Liz Garlinge
Strategic Customer Projects
Director
National Highways
The Cube
199 Wharfside Street
Birmingham
B1 1RN

27 October 2023

GATWICK NORTHERN RUNWAY PROJECT - RELEVANT REPRESENTATION

Checked By JF		Checked Date 31/05/23		Drawn By NW		Drawn Date 31/05/23	
Approved By DA		Approval Date 31/05/23		Reason for Issue DCO Submission		Status S4	
Project Code-Location-Discipline-Volume-Type-Unique Number 41700- XX -B- LLO- GA - 200151							Revision P01

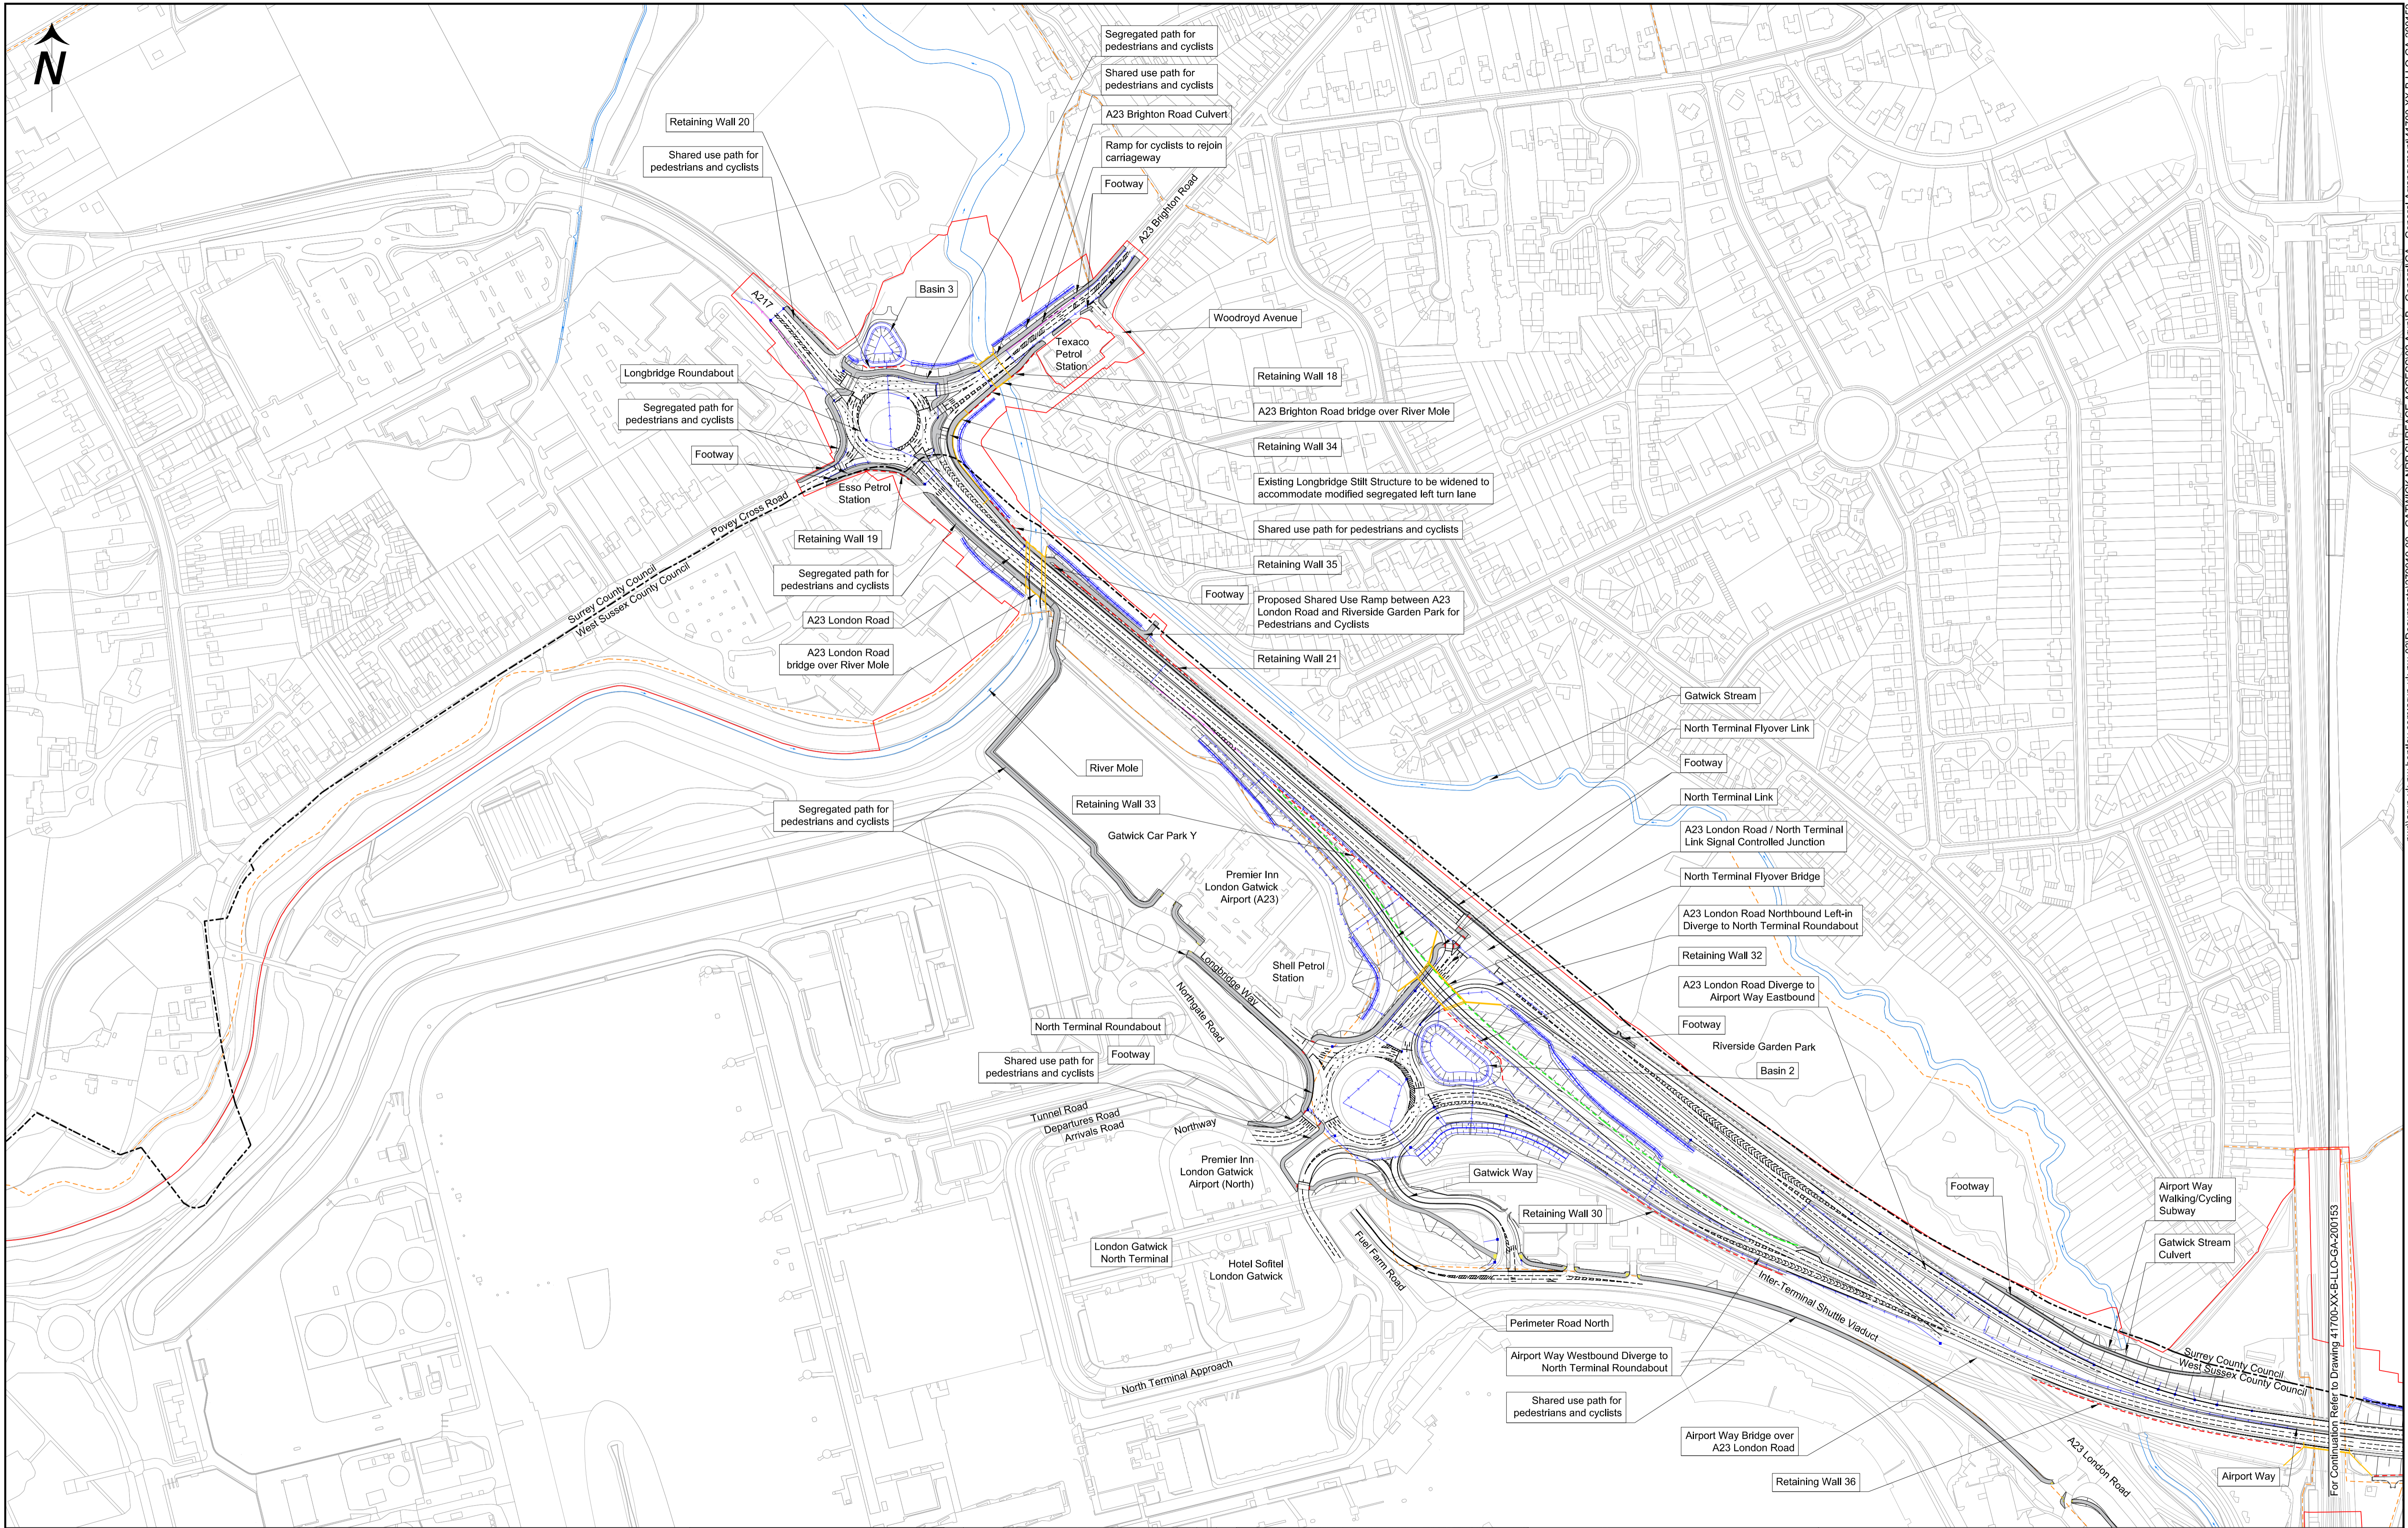
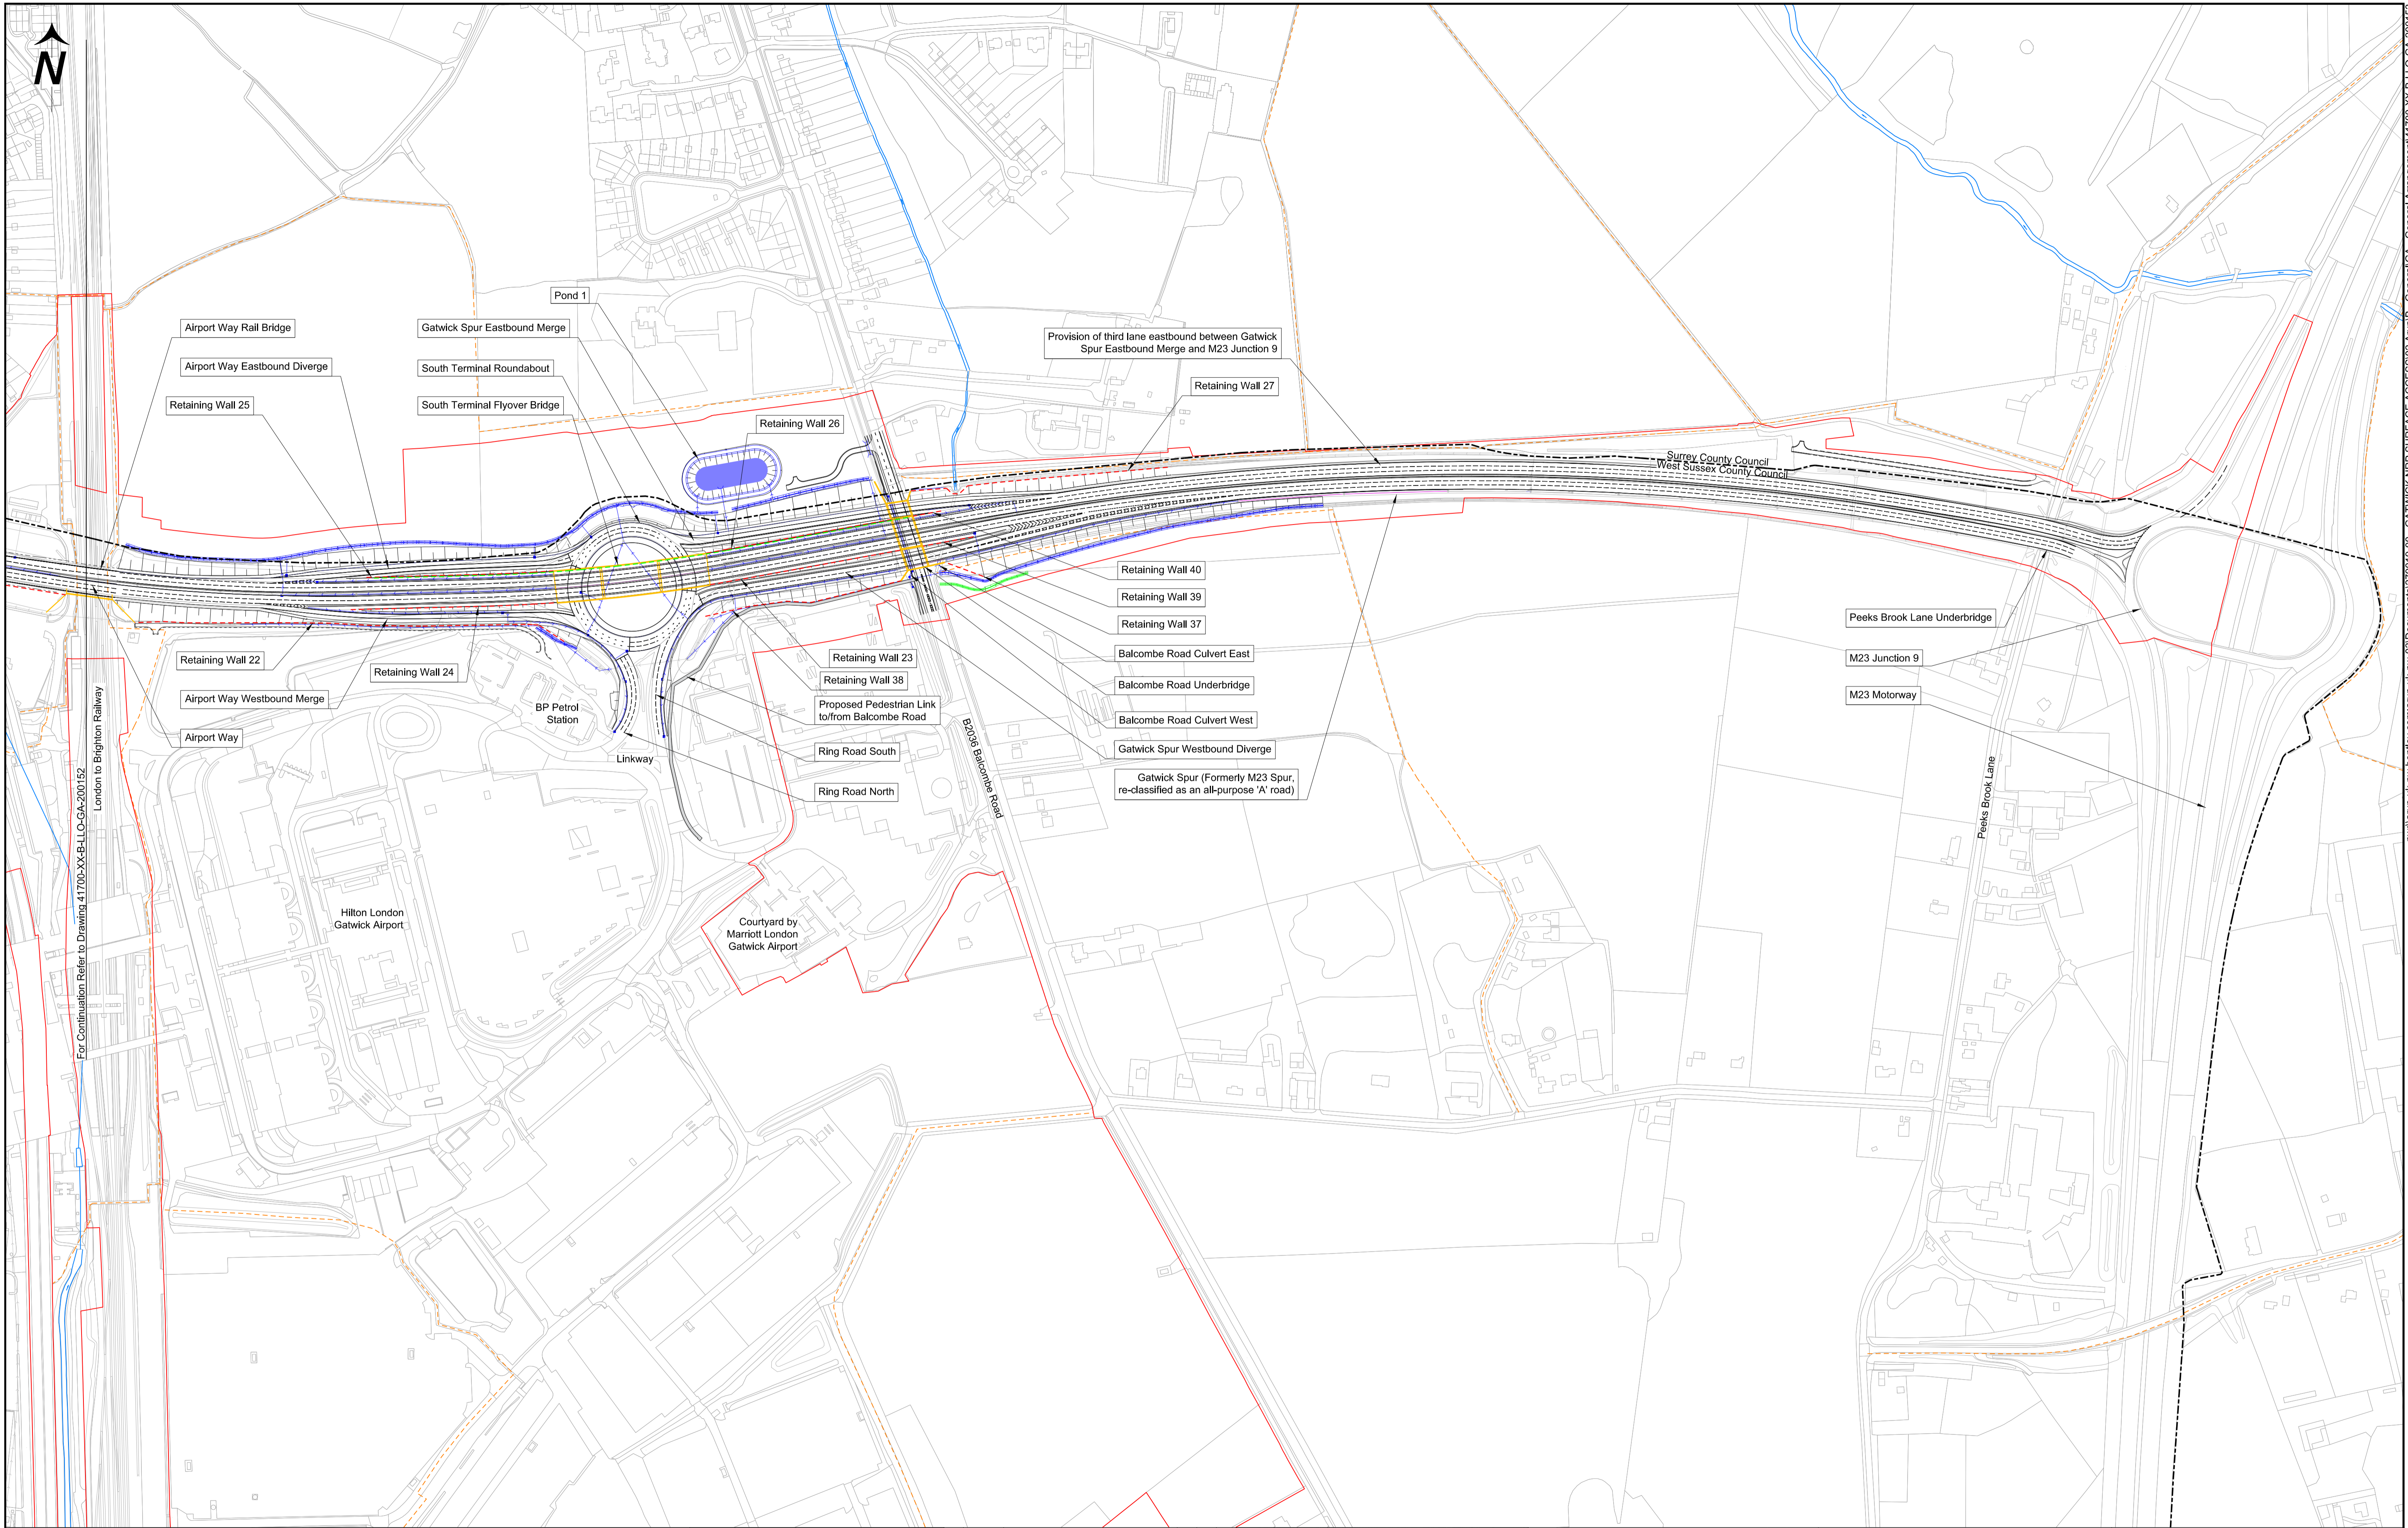
Surface Access Highways Plans – General Arrangements (TR020005/APP/020) Airport Way Rail Bridge Parapets	The Applicant proposes to widen the Westbound deck and provide parapets to the latest design requirements of DMRB CD377 – Requirements for Road Restraint Systems. However, the Applicant makes no reference to the Eastbound carriageway. Failure to identify this, risks the Applicant underestimating the scope of the works and therefore the level of disruption to the SRN	If no assessment has taken place, National Highways requests that the Applicant implement a Road Restraint Risk Assessment Process (RRRAP) for the Eastbound alignment to assess if the existing parapet and approach road restraint system will meet current standards.	Medium
Surface Access Highways Plans – General Arrangements (TR020005/APP/020) Balcombe Road Underbridge	National Highways notes that the mainline and slip road bridges will be sited near one another. National Highways is concerned that the proximity of these structures will generate additional maintenance challenges or restrictions.	National Highways requests that the Applicant considers maintenance requirements and agree these principles with National Highways, to provide confidence that all activities can be undertaken safely.	Medium
